From: Martyn White
Sent: 18 January 2019 09:52
To: Planning.Responses
Cc: Anita Gardner
Subject: A/157/18/DOC

A/157/18/DOC

The application relates to the finishes to be used for the supporting piers which are located on the front elevation of the property. I note that the proposal is to use two different materials; brick and black stained timber cladding. Such materials seem to be acceptable in particular instance.

Rev	Description	Date
Job Reference		Client
New House The Cottrells Angmering, BN16 4AF		AM Homes Ltd
Drawing Title		Drawing No Rev
Supporting Pier Details		ADC962/19
Date	Scale	Dwg Size
10,11,18	1:100/20	A3
Plot Style	Drawn	Checked
ADC+red	AD	AD

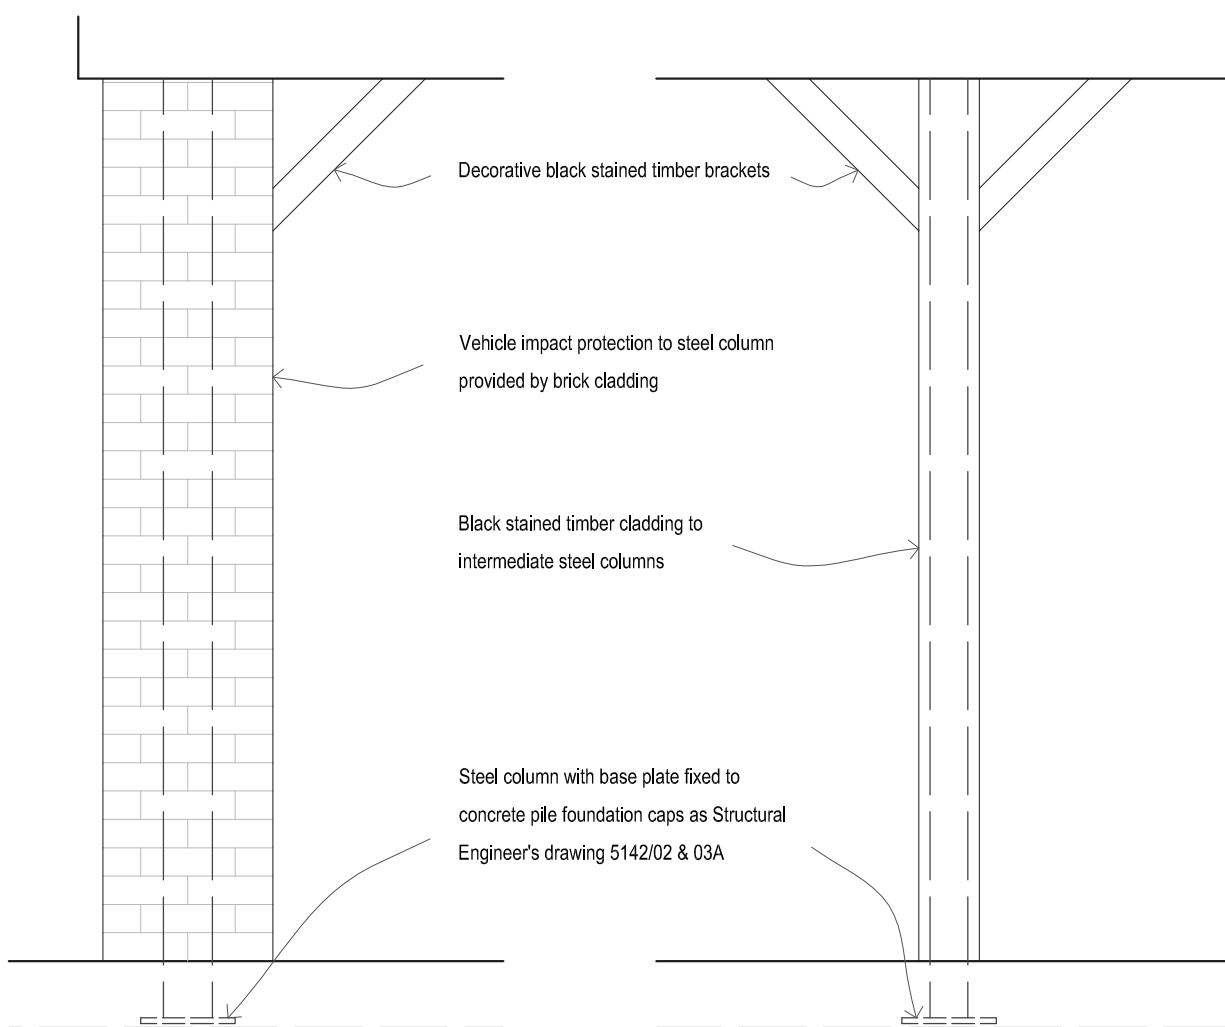
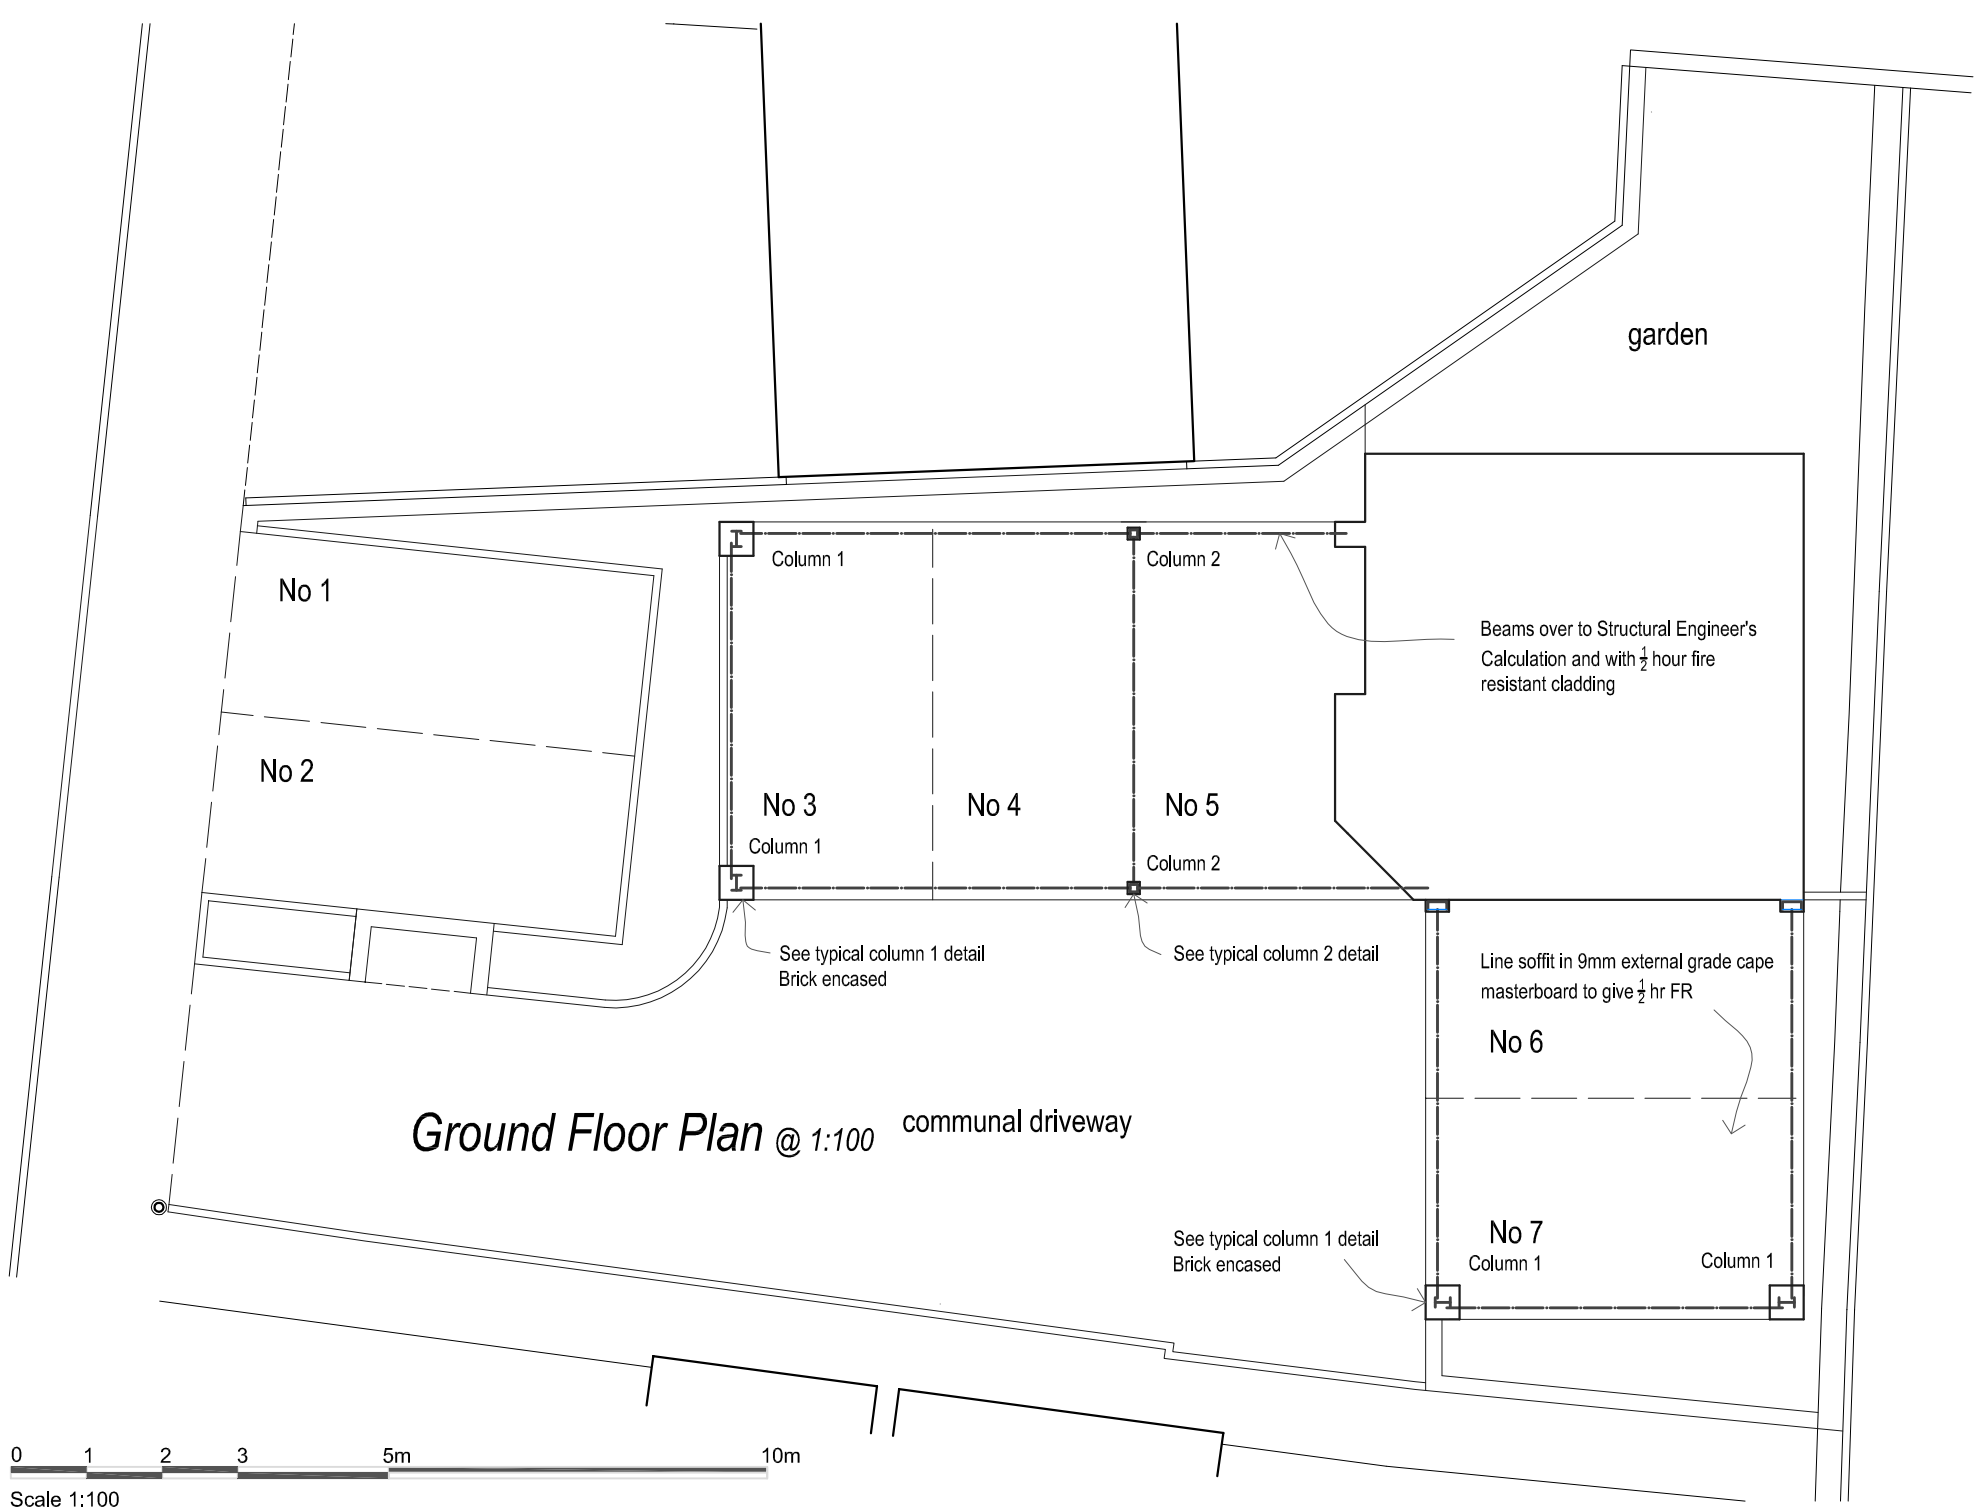
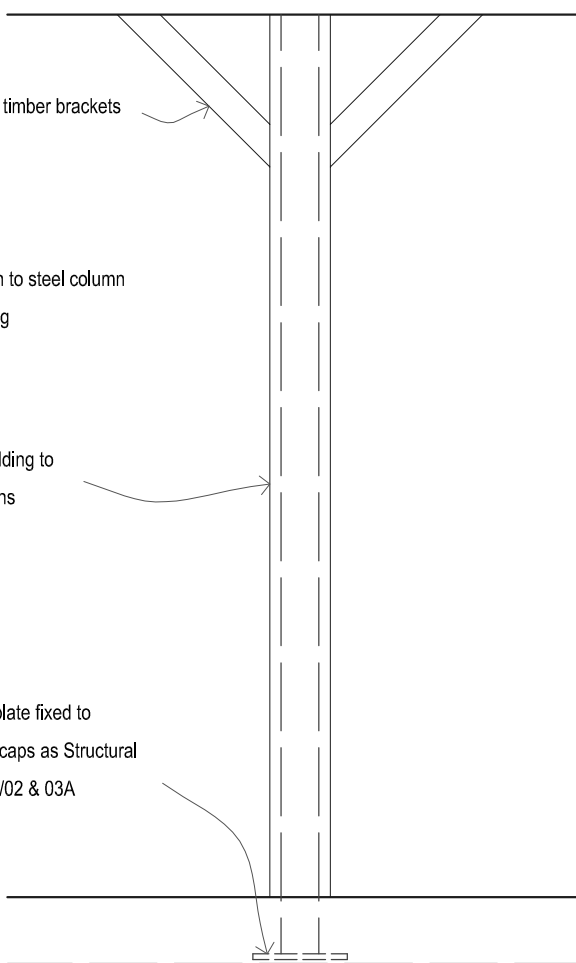
It is therefore considered that as long as the brick matches that already approved by the LPA, that the condition may be discharged.
